# City of Albuquerque

**Re: Onate E. S. Kindergarten Building  
12415 Brentwood Hills NE  
Request Permanent C.O. - Accepted  
Engineer's Stamp dated: 6/17/2010 (H22D035)  
Certification dated: 3-14-16**

**Re: Onate Elementary School Private Fire Road Grading and Drainage Plan  
Engineer's Stamp date 3-2-10 (H22/D035)**

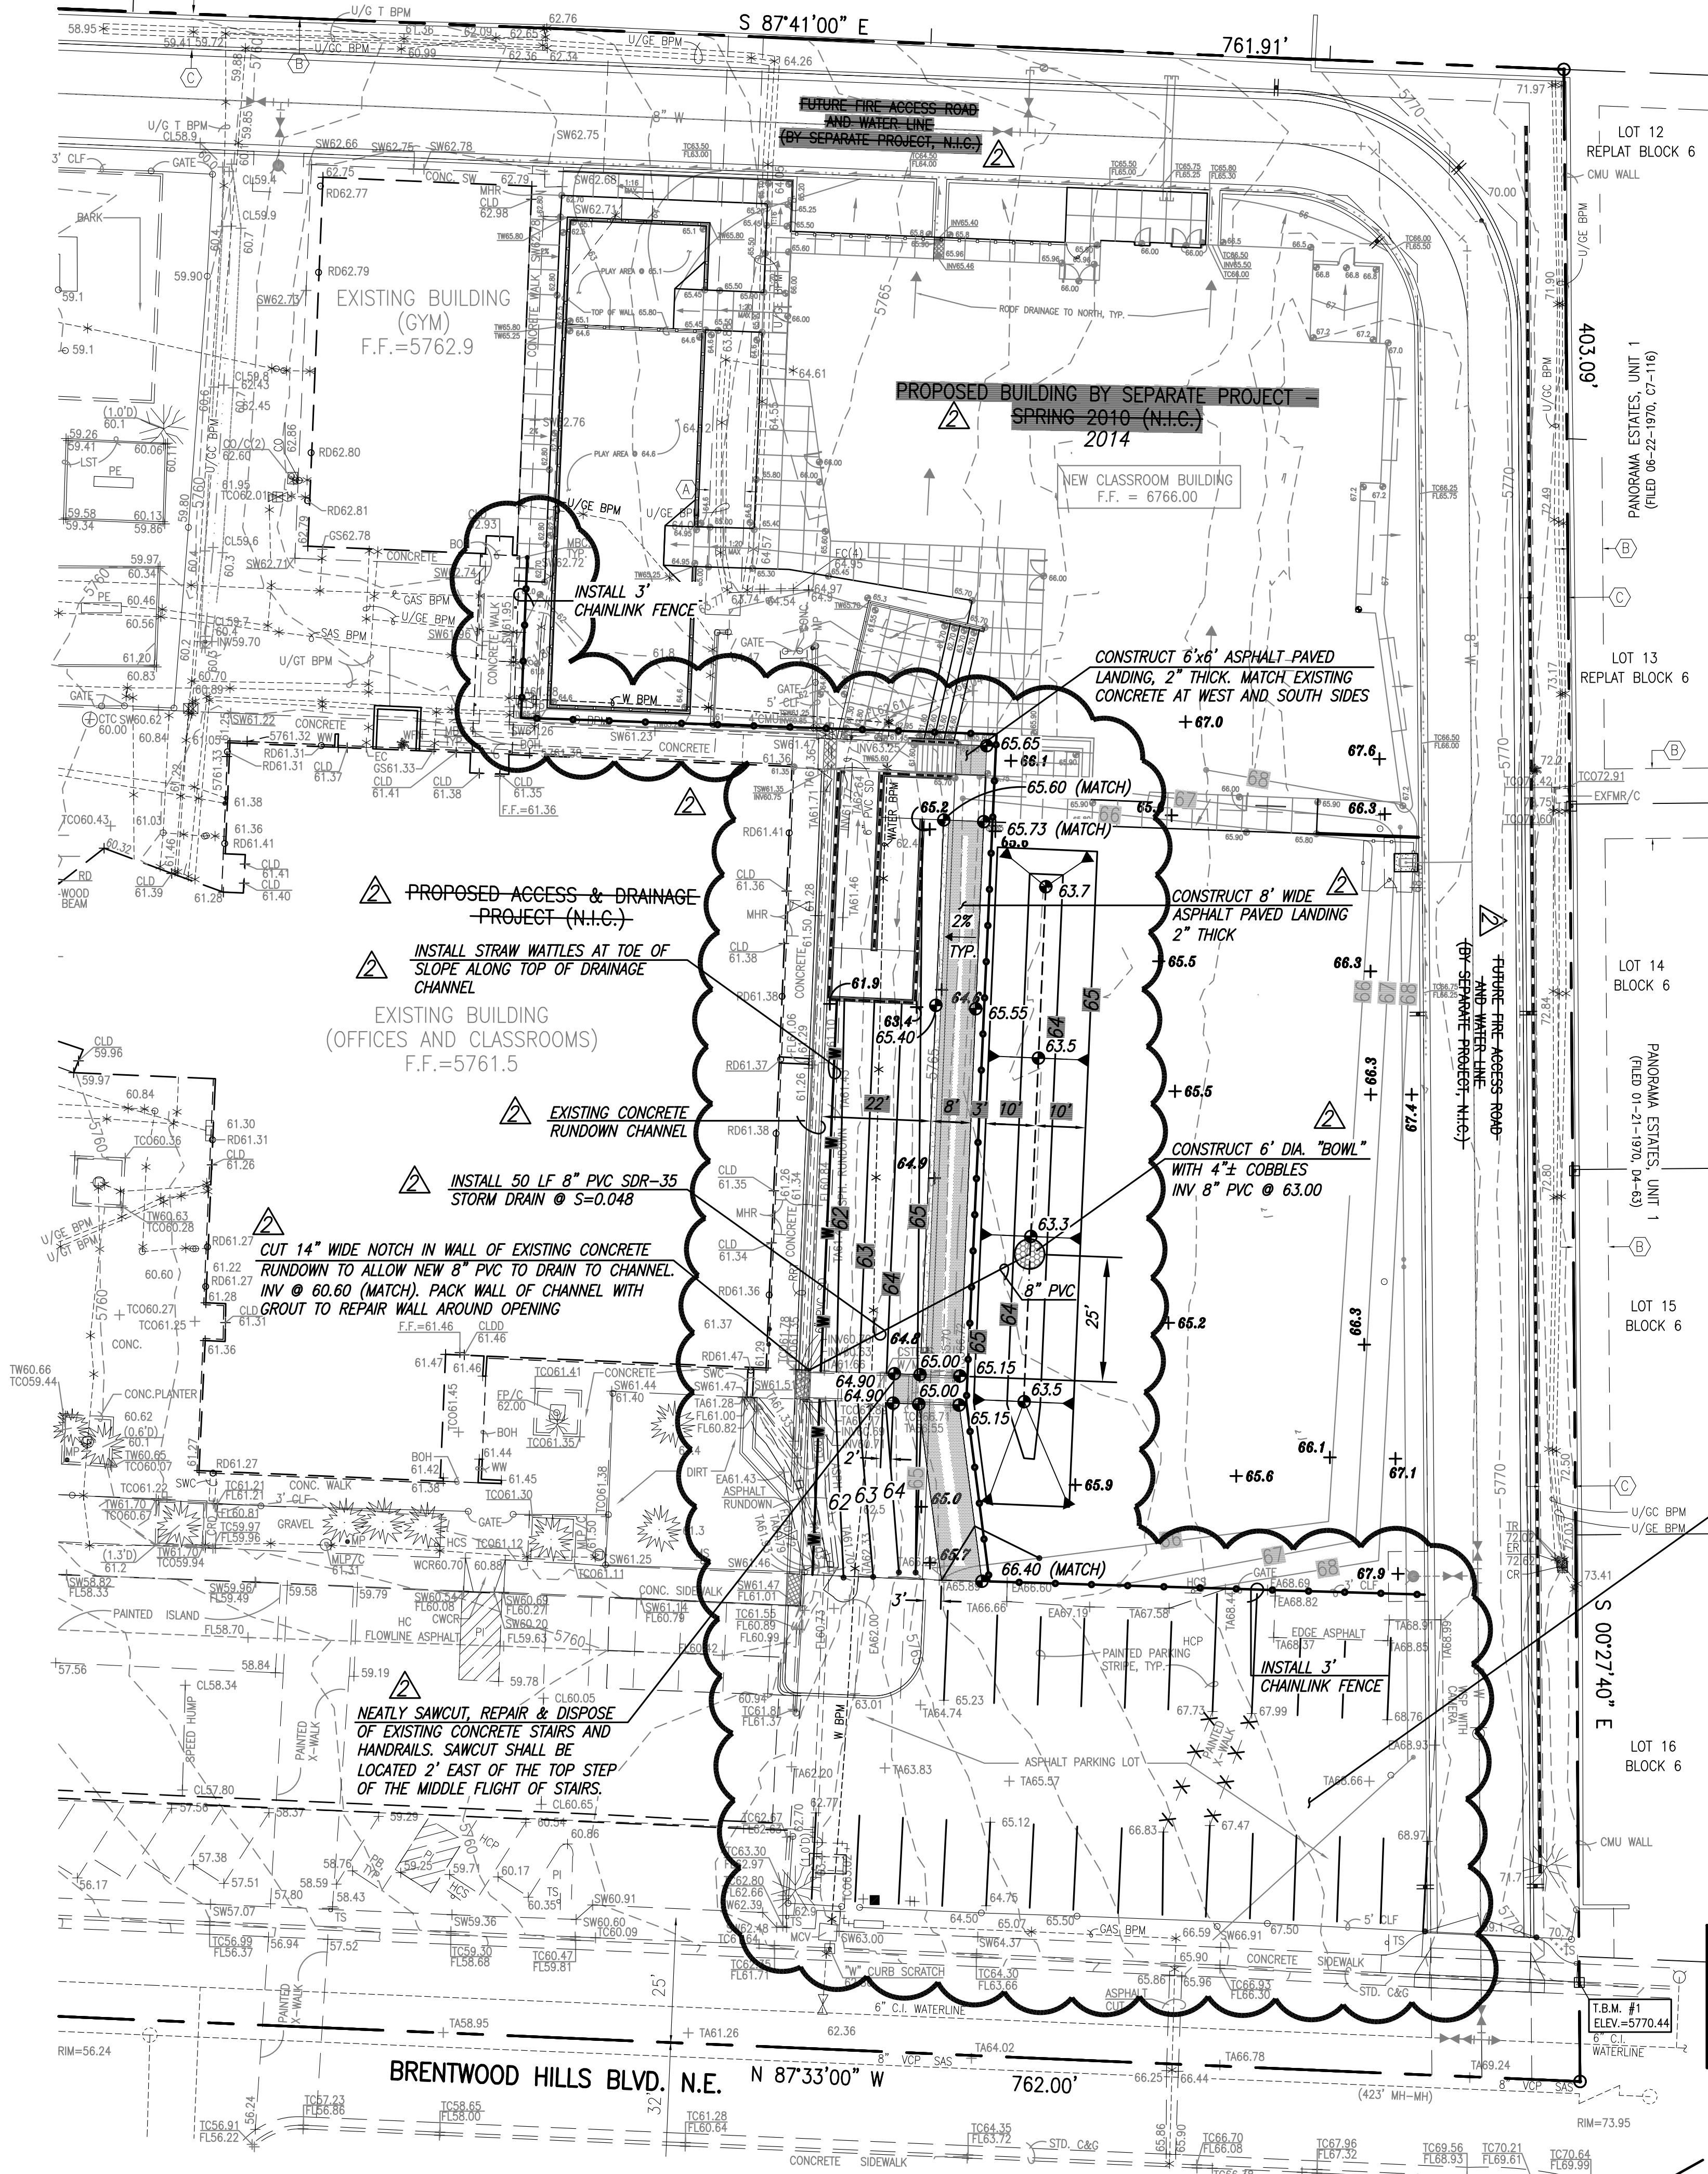
- It appears the fire lane does not have capacity on the west side of the site where the slope is 0.007. I calculated the capacity of the road as 14.5 cfs and assumed the flow to be 19 cfs (Basin A + Basin C – 2 cfs). Provide street flow calculations.
- At the west corner in the fire road, momentum may carry the runoff over the 6" curb.
- On Sheet C-106, Keynotes 19, 20 and 21 are missing. Keynote 4 indicates it is not used, however the legend specifies Proposed Asphalt.
- How wide is the proposed curb cut near the downstream end of the channel on Sheet C-106?
- Why is a high point (64.6) proposed upstream of the proposed 2 foot channel? Besides damming up an area it creates a 2:1 slope.
- Sheet C-106 requires a date and signature on the P.E. stamp.
